From: Patel, Uday [Uday.Patel@lancashire.gov.uk]
Sent: 11 December 2013 10:30
To: planning
Cc: ENV LHS Customer Service
Subject: 3/2013/0926 - Proposed double garage with increased width of access from road - Church Gates
14 Sawley Road Chatburn BB7 4AS

Planning Application Reference: 3/2013/0926

Proposal: Proposed double garage with increased width of access from road

Location: Church Gates 14 Sawley Road Chatburn BB7 4AS

Project	Proposed garage & Car Port
Client	Mr & Mrs Barton Church Gates, Chatburn
Title	Scheme Drawing
Scale 1:50	Date 27/10/13 Dm
Drng N°	385/1/2

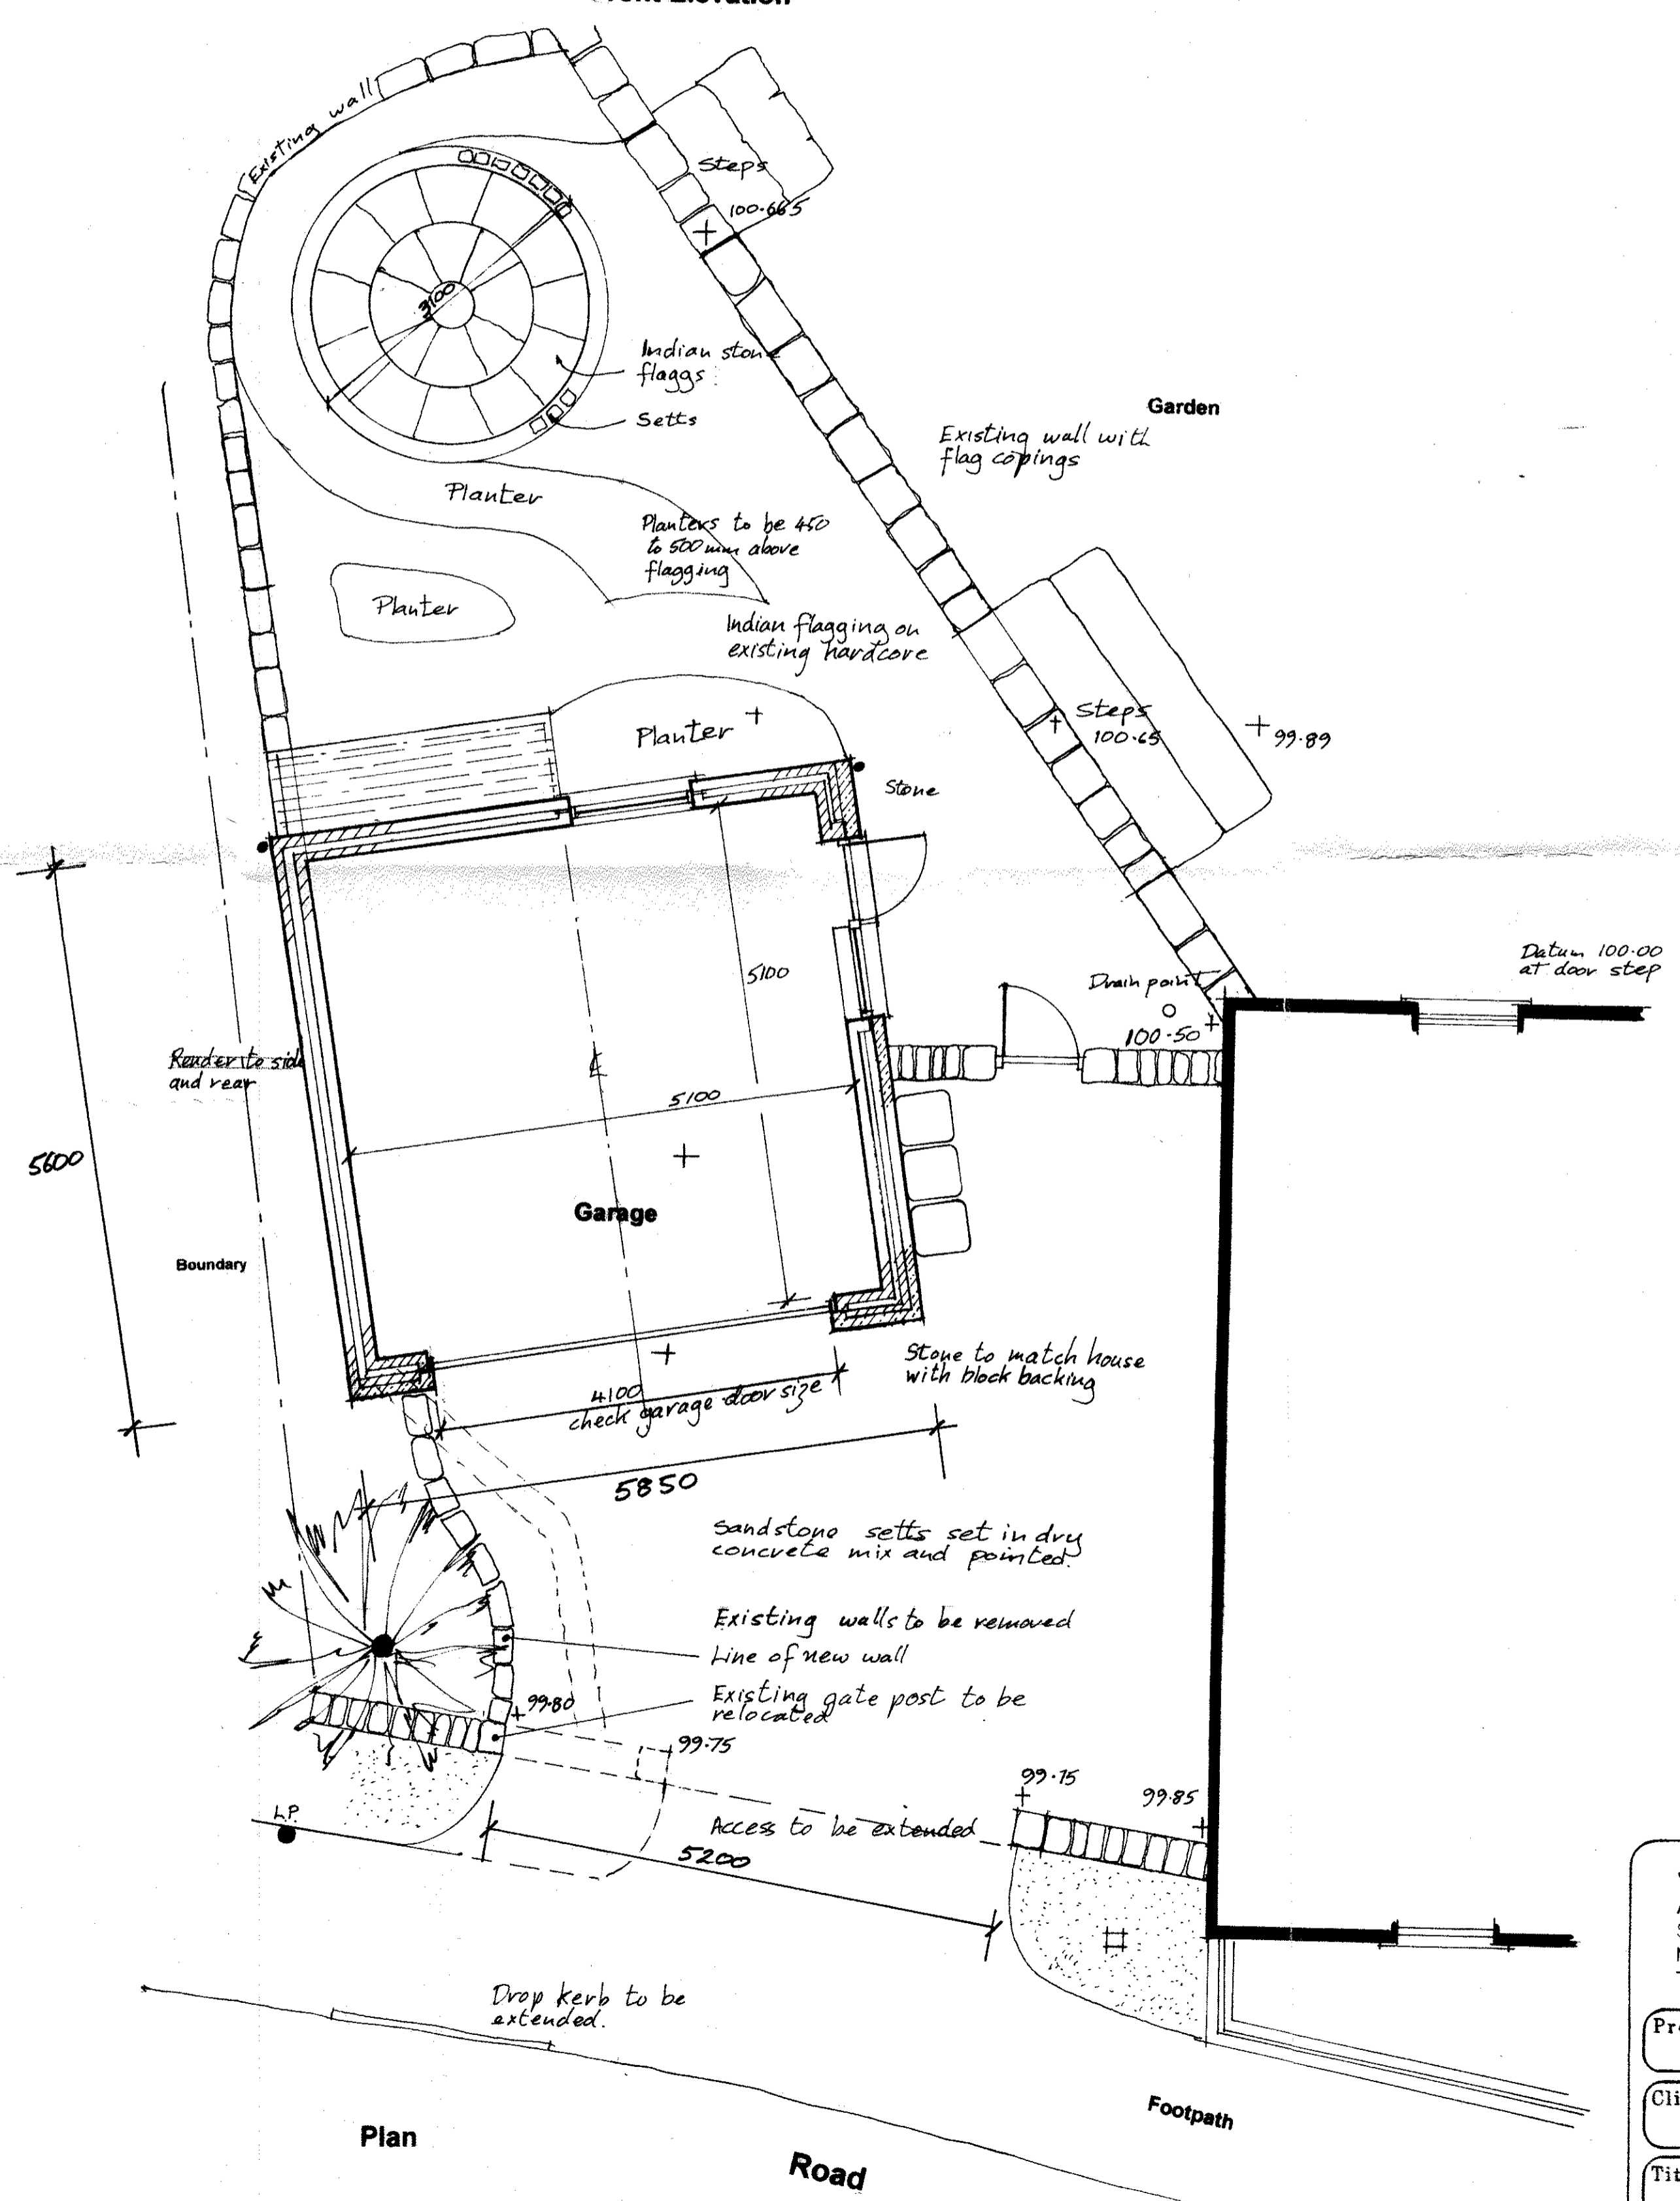
Proposed erection of double garage is meant for accommodating two vehicles within the garage. There are concerns regarding proposed dimensions of double garage. According to manual for streets, standard dimension for a single garage is 3mx6m. Dimensions of double garage indicated in the layout is 4.1 (door entrance) x 5.1m . It is realised that proposed dimensions is unlikely to accommodate two vehicles safely within the garage. This situation will result in loss of parking space then previous use. This situation will also result in loss of available parking space in front of garage for accommodating another vehicle. This situation is not acceptable.

Proposed garage shall be setback 5.5m from back of the foot way with the provision of vertical lift rolling shutter. It is not clear if this is the case. This is required for not to affect on going traffic on Church Gate road while entering the property from road.

1. Dimensions of double garage shall be minimum 5m (door entrance width) x 5.5m depth without considering accommodation of bicycles in the garage.
2. Front edge of the garage shall be setback 5.5m from the back of the footway with the provision of vertical lift rolling shutter type door.
